Jeff Levine, AICP, Director  
Marge Schmuckal, Zoning Administrator

October 11, 2012

Re: 5 Bramblewood Drive – 377 E006 – R-3 Residential Zone – Permit #2012-10-5099  
–daycare as home occupation

Attached you will find a copy of a floor plan showing my entire dwelling and area of the home daycare.

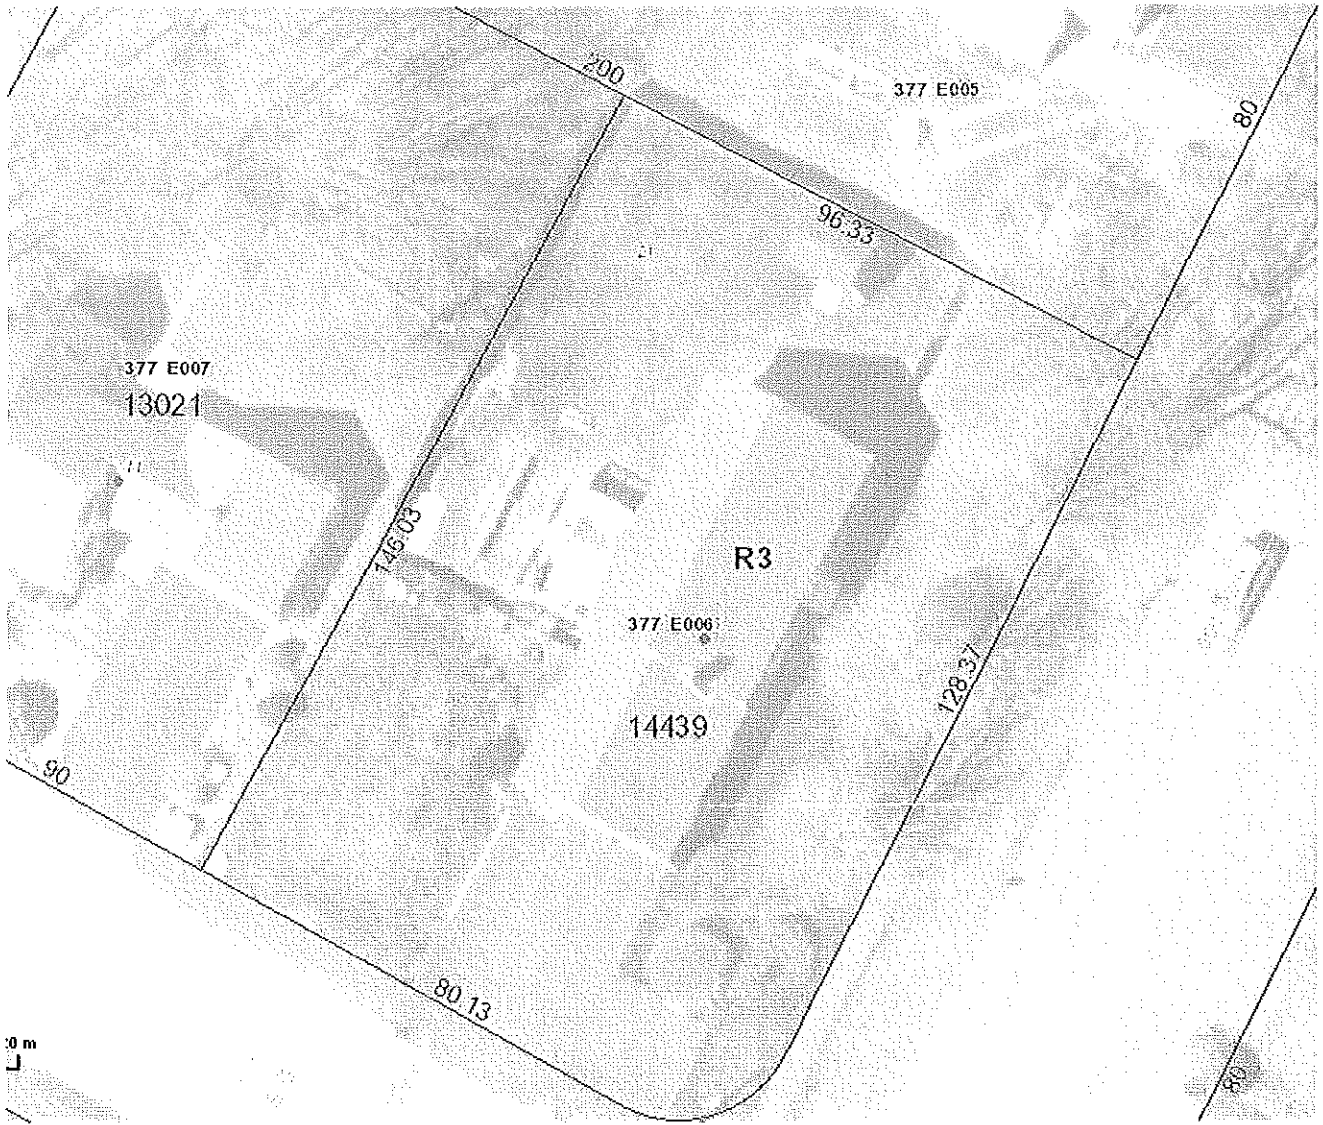
In reviewing your application to add a daycare as a home occupation, I noticed on your floor plans that there are two kitchens in the home, one on the main floor and one on the lower level. Our records show the legal use of the property as a single family home or a single dwelling unit. Section 14-47 defines a dwelling unit as “one (1) or more rooms with private bath and kitchen facilities comprising an independent self-contained dwelling unit”. In other words a dwelling unit has one kitchen. A second kitchen in a building changes the use of the building from one dwelling unit to two dwelling units. I have researched our records, and there is no record of a second kitchen being added to the building. Since the use of the building is one dwelling unit, the second kitchen is illegal and needs to be removed.

Your application meets all the other criteria for a daycare as a home occupation for six children plus two children after school. I am signing off on the permit for zoning with the condition that the second kitchen needs to be removed before the certificate of occupancy is issued for you to operate a daycare as a home occupation. Section 14-47 of the

ordinance defines kitchen facilities as “facilities used for the preparation of meals, including refrigerators and devices used for the cooking and preparation of food”. In one of our telephone conversations you said that there was a full sized refrigerator and a stove in the lower level. These would have to be removed along with any sink and other device used for cooking and preparation of food.
